From: Chelsea Benner
Sent: Tuesday, September 26, 2017 11:08 AM
To: Holly Duncan
Subject: BL-17-00015 Kohl
Attachments: BL-17-00015 Kohl Preliminary Survey Pg 1 Revised.PDF

From: Holly Duncan
Sent: Wednesday, September 13, 2017 9:27 AM
To: Chelsea Benner
Subject: RE: BL-17-00015 Kohl

From: Chelsea Benner
Sent: Wednesday, August 30, 2017 8:38 AM
To: Holly Duncan; Holly Myers; Joe Seemiller; Josh Hink; Justin Turnbull; Kelly Bacon
Subject: BL-17-00015 Kohl

BOUNDARY LINE ADJUSTMENT
 PREPARED FOR
 PETER KOHL
 A PORTION OF THE SW 1/4 OF THE NE 1/4 OF SECTION 4,
 TOWNSHIP 19 NORTH, RANGE 15 EAST, W.M.

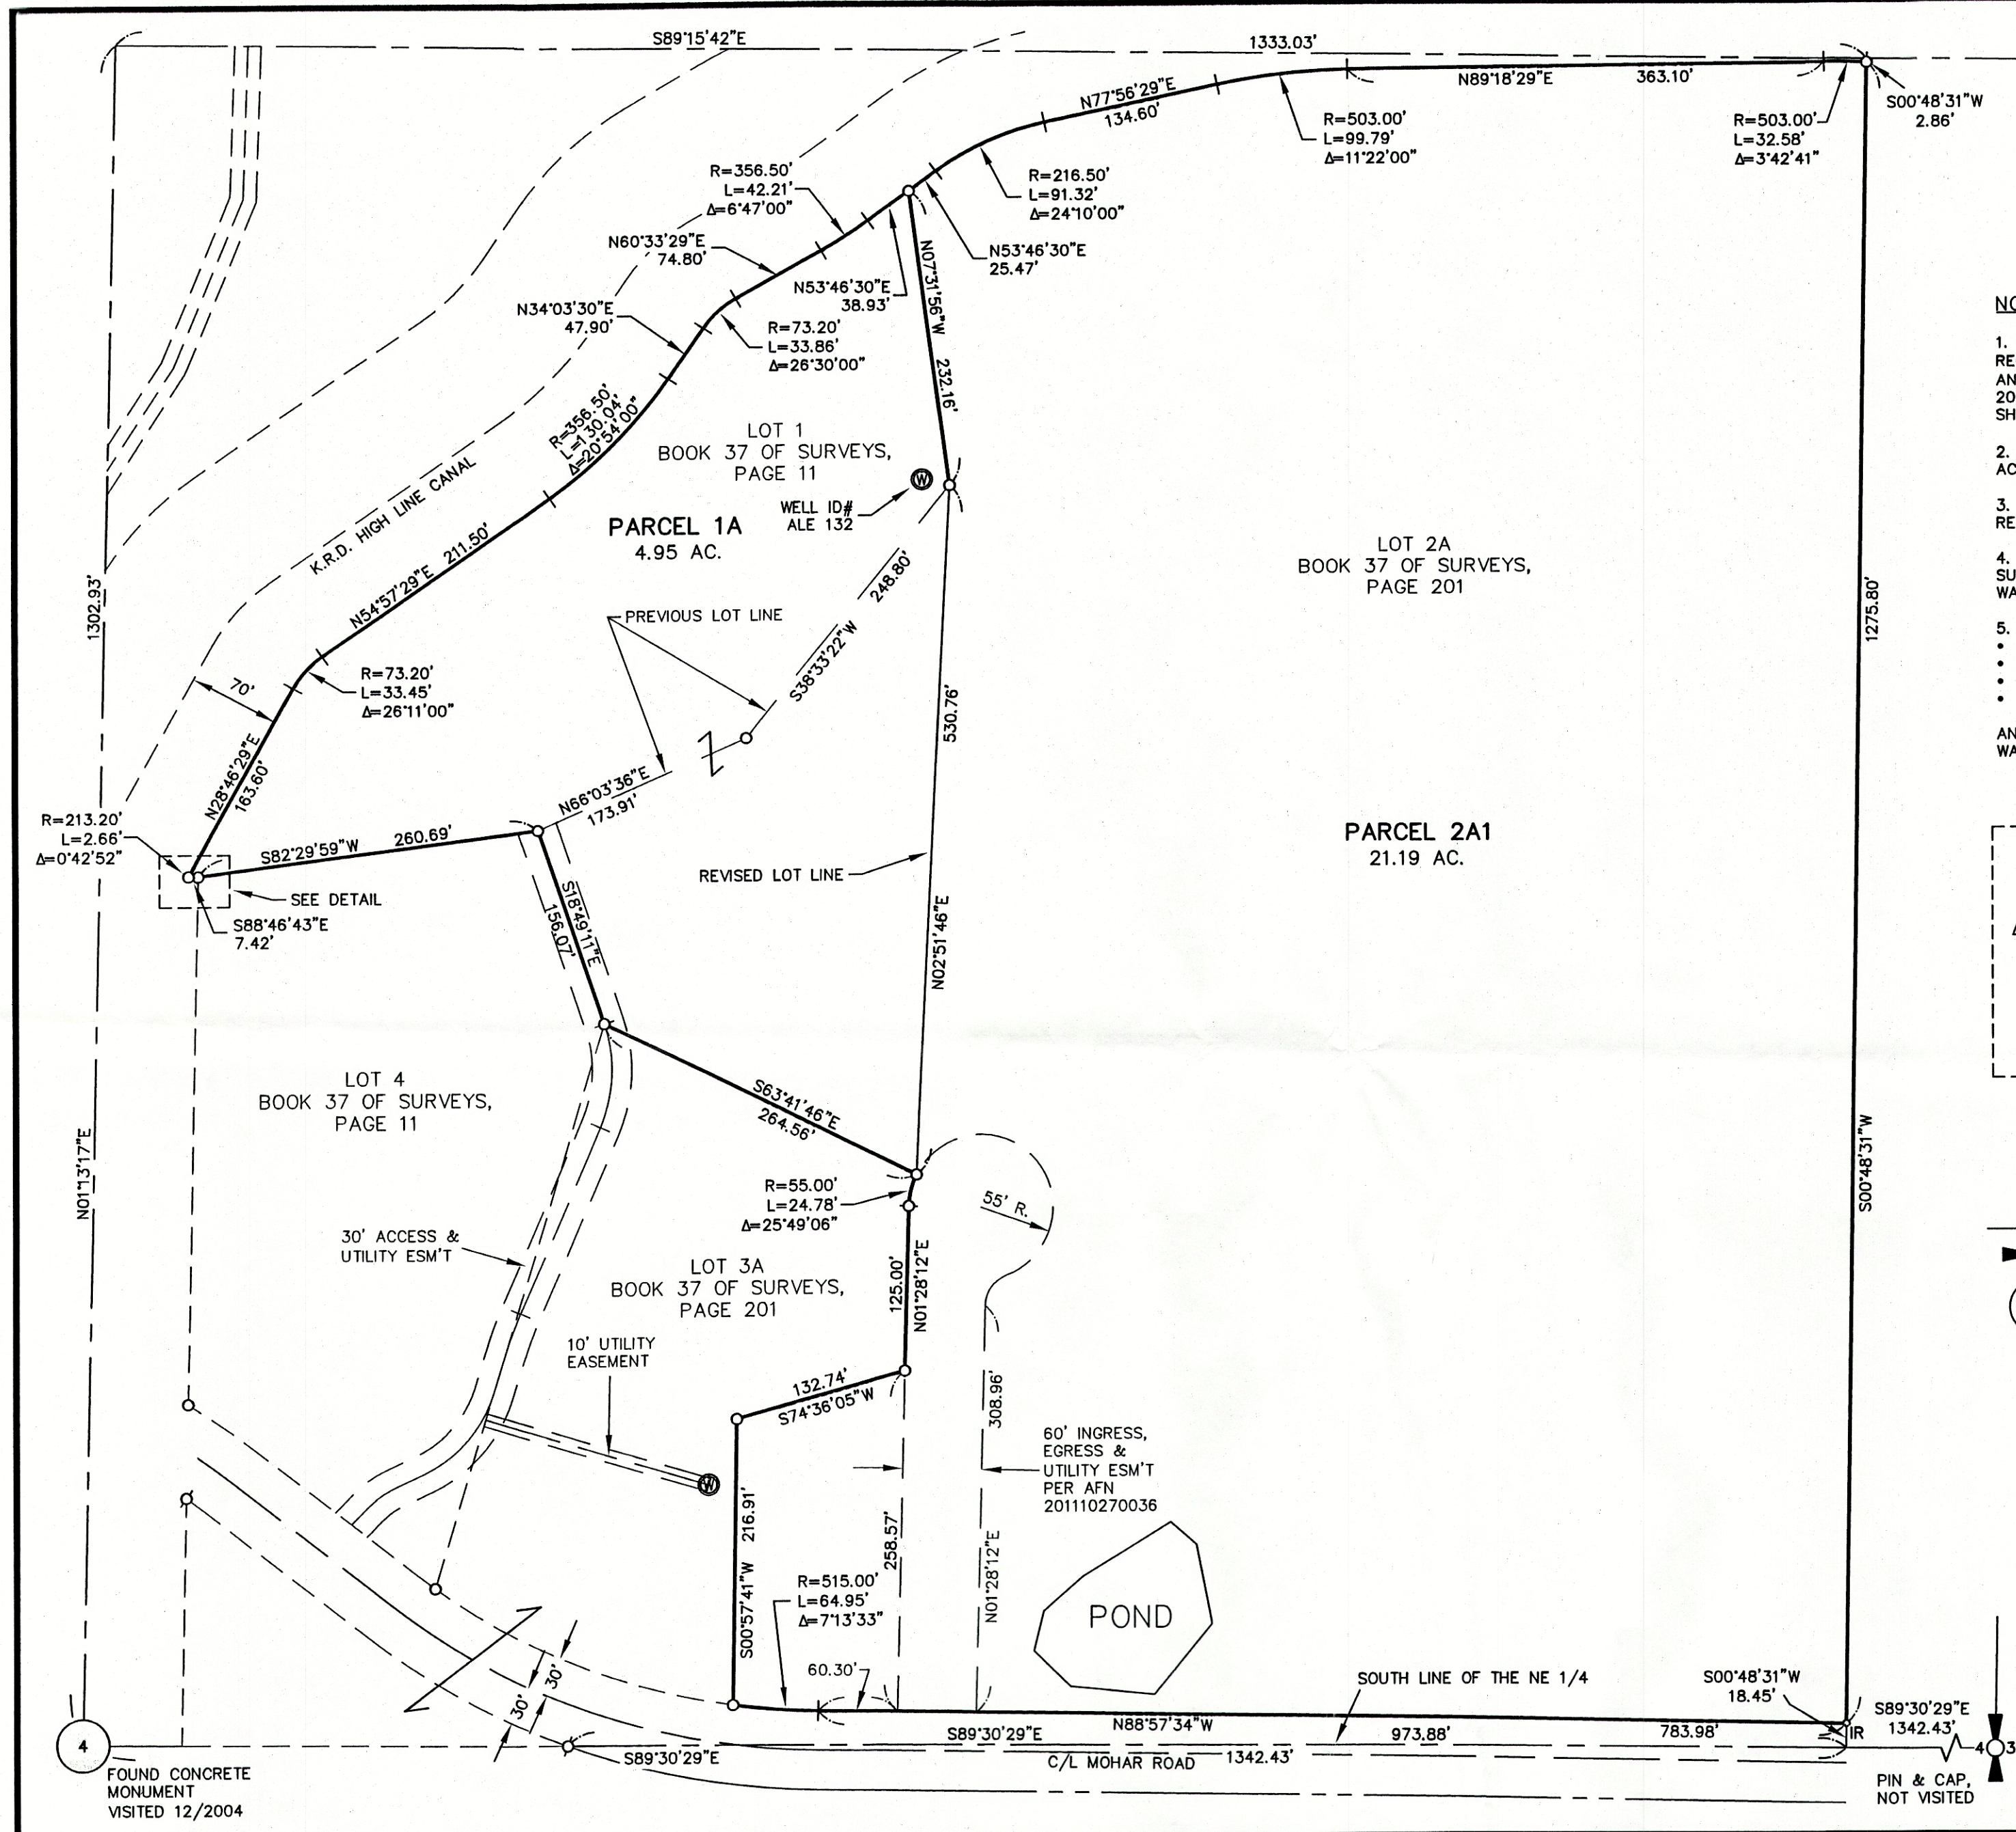
It looks like the property has two existing wells. Do we know how far those wells are from the closest property lines?

Attached is a new preliminary survey with the location of the wells. Please let me know if you have any further comments.

Attached is a copy of our revised preliminary boundary line adjustment map for BL-17-00015 Kohl. Sheet 1 now shows the locations of the two wells in question. If you need anything else, please let me know. Have a great day!!
